WEST SUSSEX COUNTY COUNCIL CONSULTATION

TO:	Arun District Council FAO: Amber Willard
FROM:	WSCC - Highways Authority
DATE:	20 July 2020
LOCATION:	22 Cherry Avenue Arundel BN18 0LB
SUBJECT:	Y/38/20/HH Replace existing dilapidated lean-to roof (north side) with improved enclosed structure. Enclose existing open front porch. Add lean-to to rear of property. Increase off-road parking with associated drop curb.
DATE OF SITE VISIT:	n/a
RECOMMENDATION:	More Information
S106 CONTRIBUTION TOTAL:	n/a

Enter map title

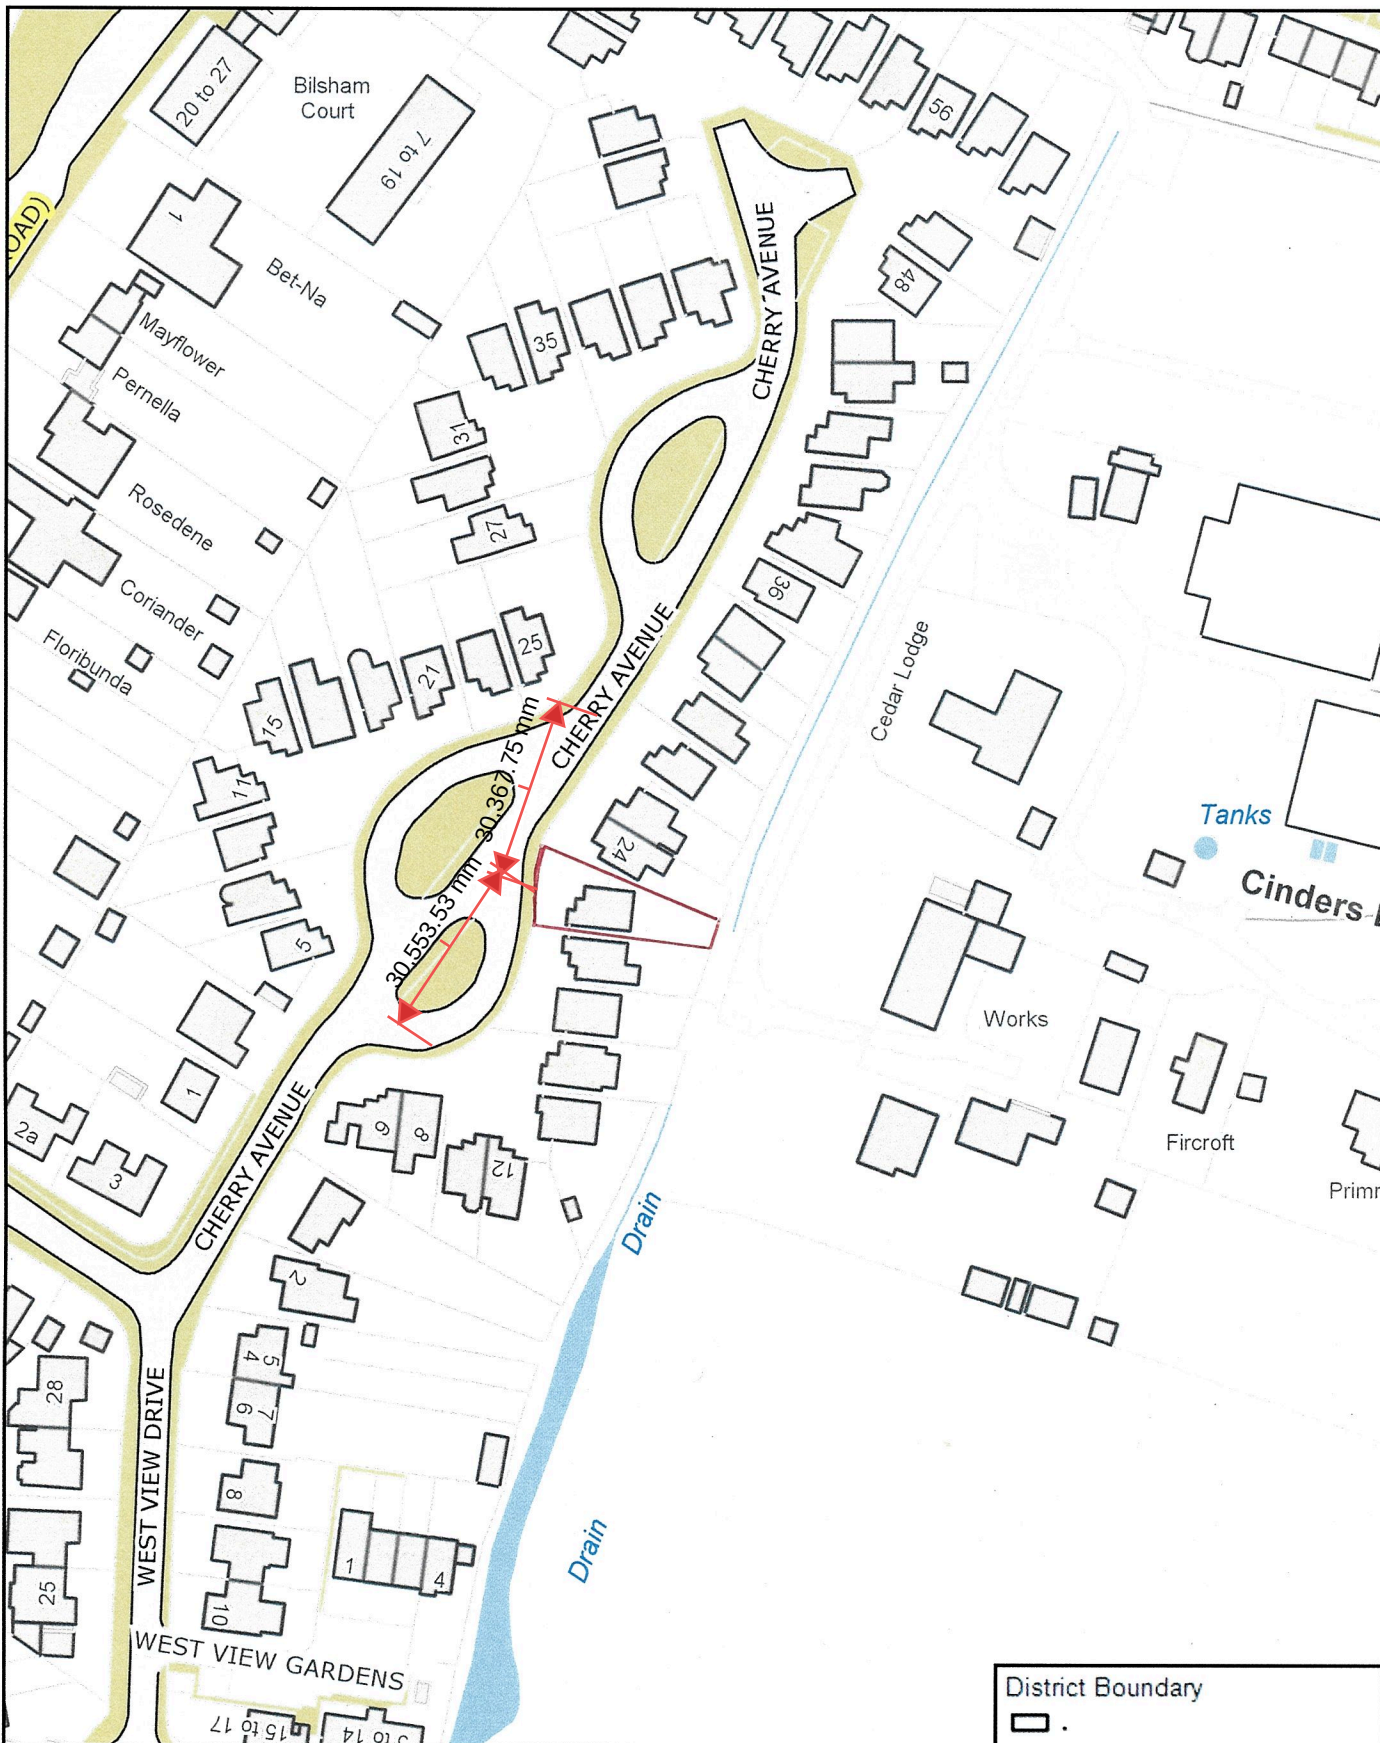
It is noted that the plan is annotated to show a 11 metre Vehicle Crossover (VCO).

The Local Planning Authority and the applicant should be mindful that the WSCC Highways Area Office, who is responsible for the issuing of VCO Licenses, do not wish to see VCO's measuring over 6.4 metres in this location due to the existing parking pressures and the loss of on-street parking provision for neighbouring residents. While this is not a highways safety issue the LHA wish that good planning practices are kept and as such, no planning application is permitted where it cannot be implemented. As a result, the LHA advises the applicant to reduce the VCO to 6.4 metres maximum.
